BOCA®
NATIONAL BUILDING CODE/1996
PLAN REVIEW RECORD

JURISDICTION Portland Cumberland Me.
 (City, County, Township, etc.)

BUILDING LOCATION Rand Rd.
 (Street address)

BUILDING DESCRIPTION (2) Two buildings, use or occupancy S-2 Low Hazard Storage, Type of Construction 3A NON-Sprinklered.

FLOOR PLAN - BUILDING 'A'

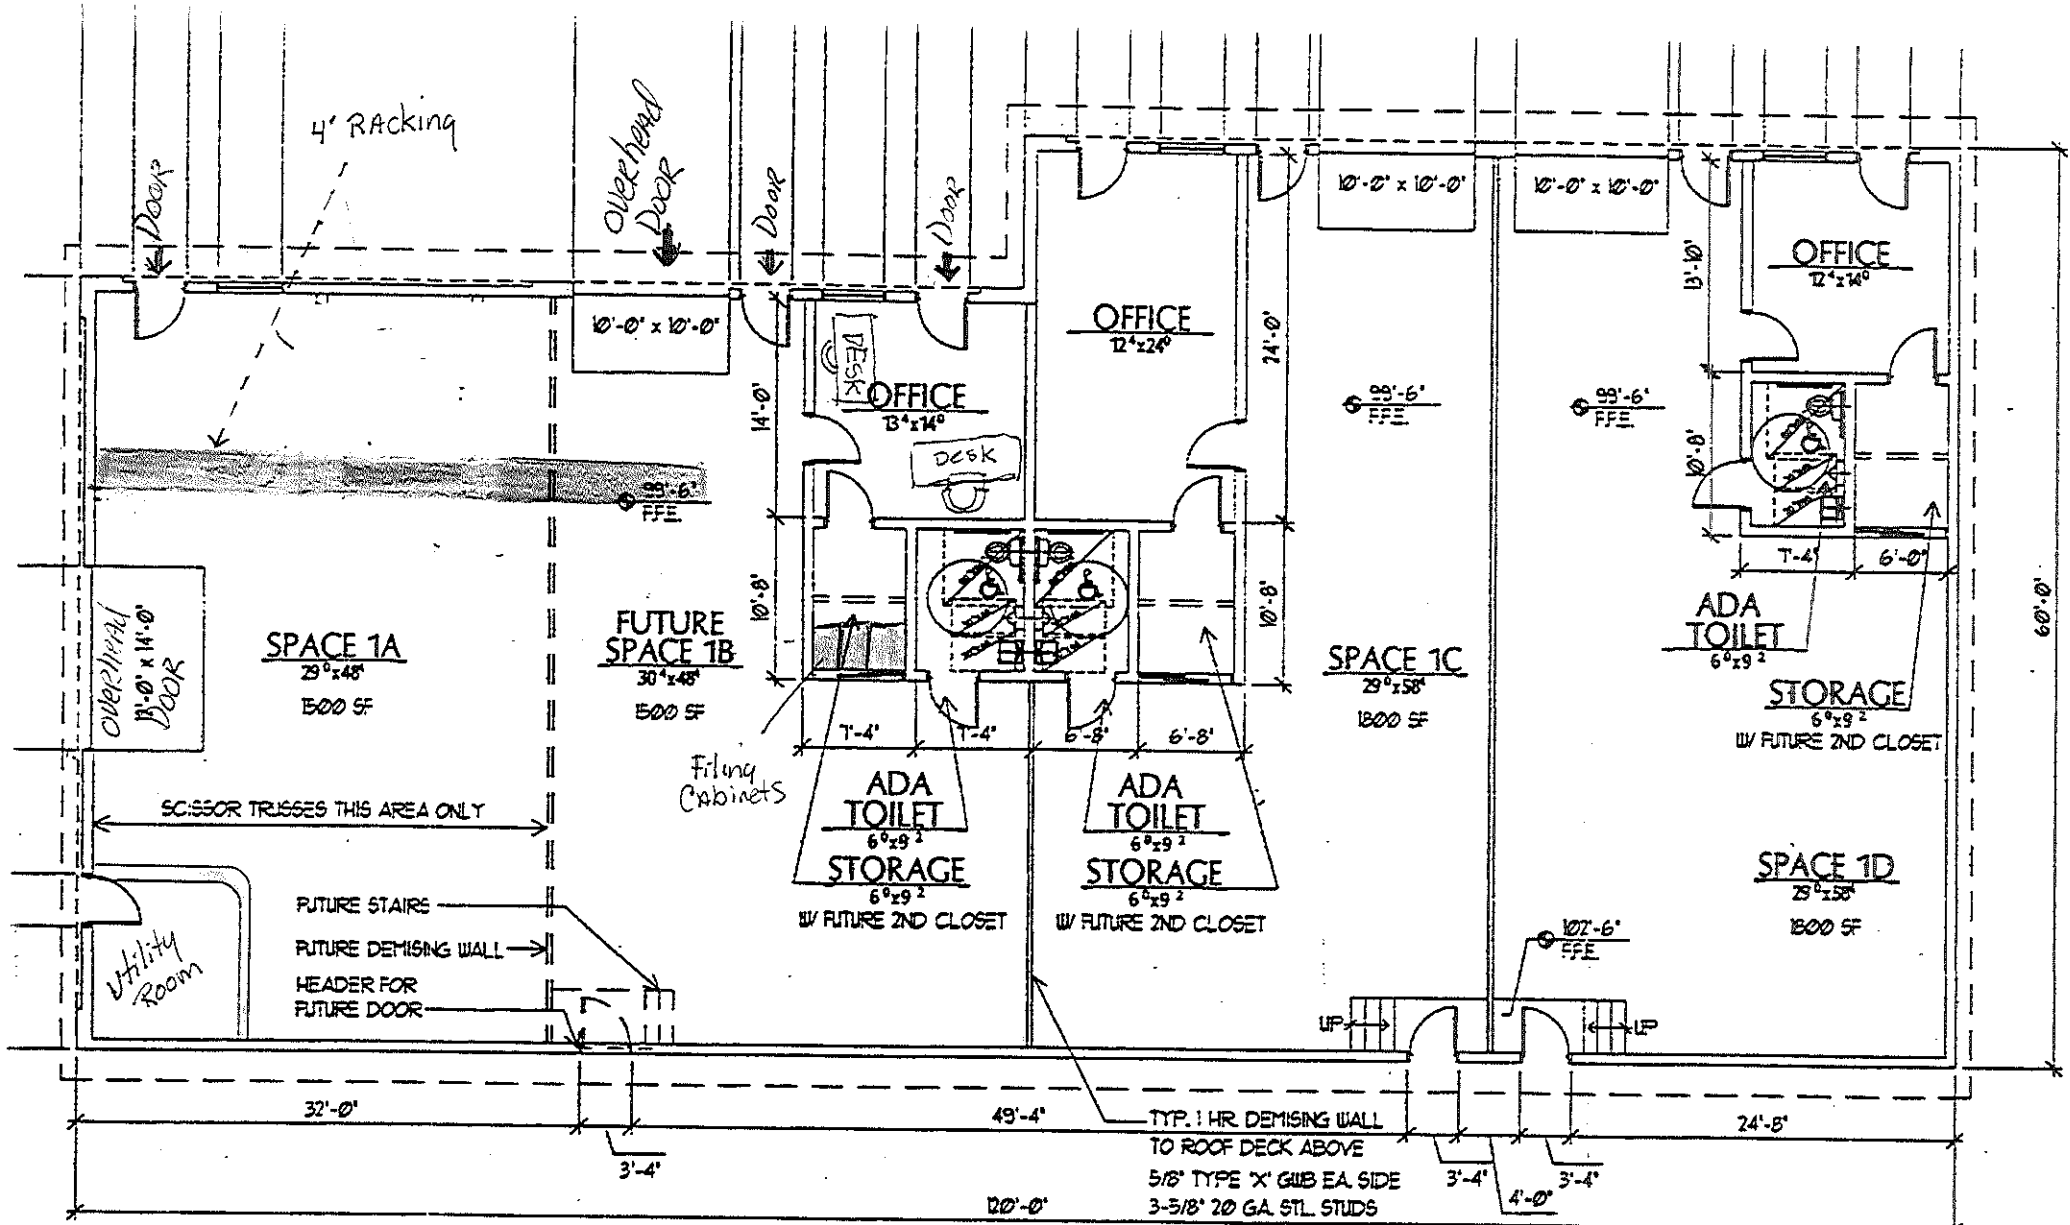
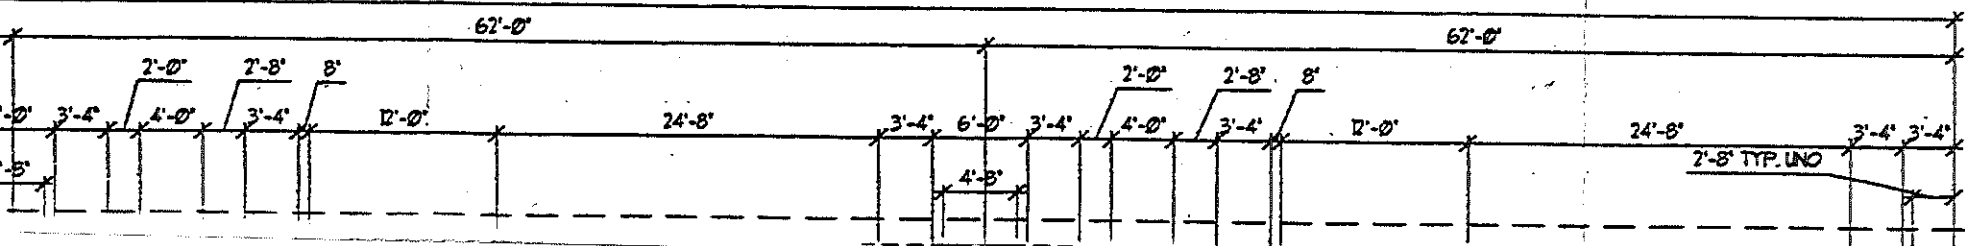
CORRECTION LIST		
No.	DESCRIPTION	Code Section
1.	All site plan requirements must be met before or a certificate of occupancy can or will be issued.	111.0
2.	This permit does not cover the future mezzanines	
3.	Fire partition	Table 602
4.	Penetration	714.0
5.	Fire dampers (Fire damper rating Table 718.1)	718.0
6.	Fire blocking & fireable draftstopping	721.0
7.	Mortar (ASTM C270)	2104.7
8.	Roof Truss design	
9.	Plans does not bear the seal, signed and date of of registered design professional.	114.0
